# HyNet Carbon Dioxide Pipeline

Written Response Statement on behalf of Peel  
NRE

Planning Inspectorate Reference: EN070007

23 May 2023

DRAWING NUMBER
 EN070007-APP-ES-6.3-Sheet 2

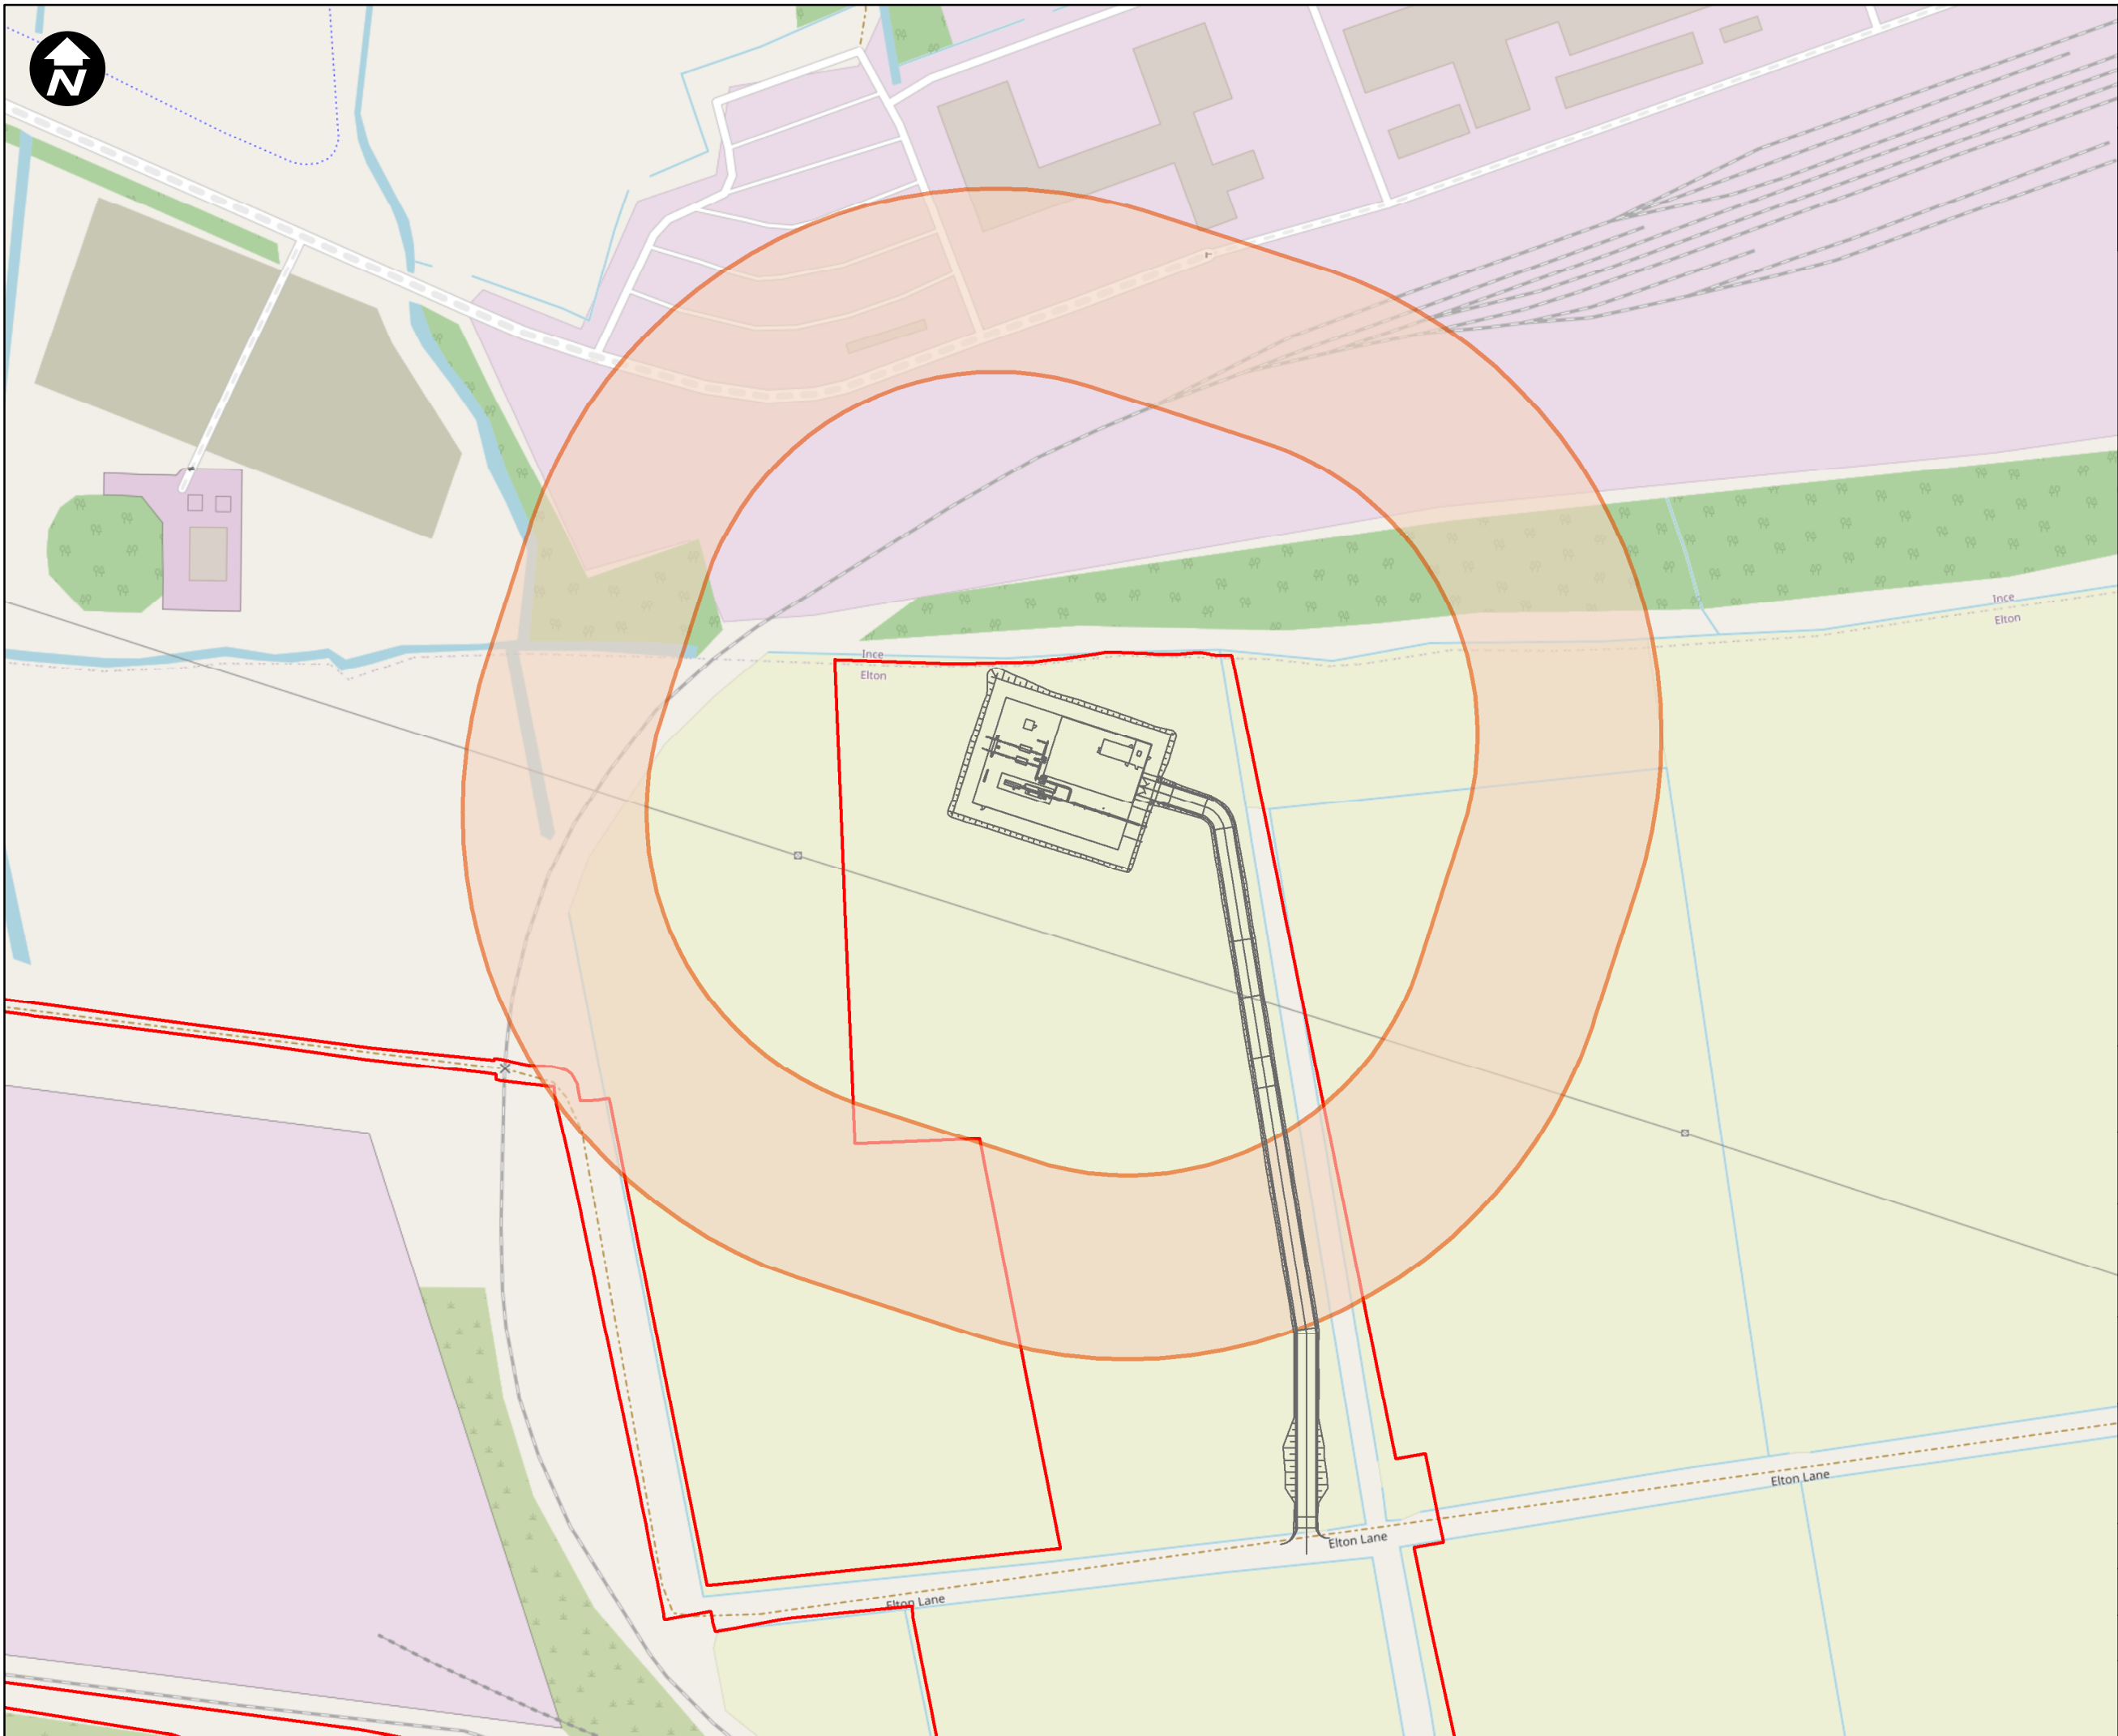
- 2.27 The Applicant has identified the potential for odour emissions at the Ince AGI, with associated Odour Zone, which lies close to Protos (shown on Figure 6.3, Rev B).

- 2.28 Within the Written Representations (17 April 2023), Peel NRE raised concerns over the assessment of odour as presented given proximity to commercial and industrial uses and the need to duly consider such receptors as part of the assessment. It was also noted that such emissions (and associated impacts) can be mitigated through the adoption of an appropriate odour management regime, secured as an odour management plan.

- 2.29 An Outline Odour Management Plan has been submitted (as Appendix 5 of the Outline Construction Environmental Management Plan, Rev A), which sets out mitigation in terms of engagement with the local community and places of work and timing of venting (during stable conditions).

- 2.30 On this basis of this information, Peel NRE is now satisfied that these matters are addressed and this will be confirmed through the SoCG.
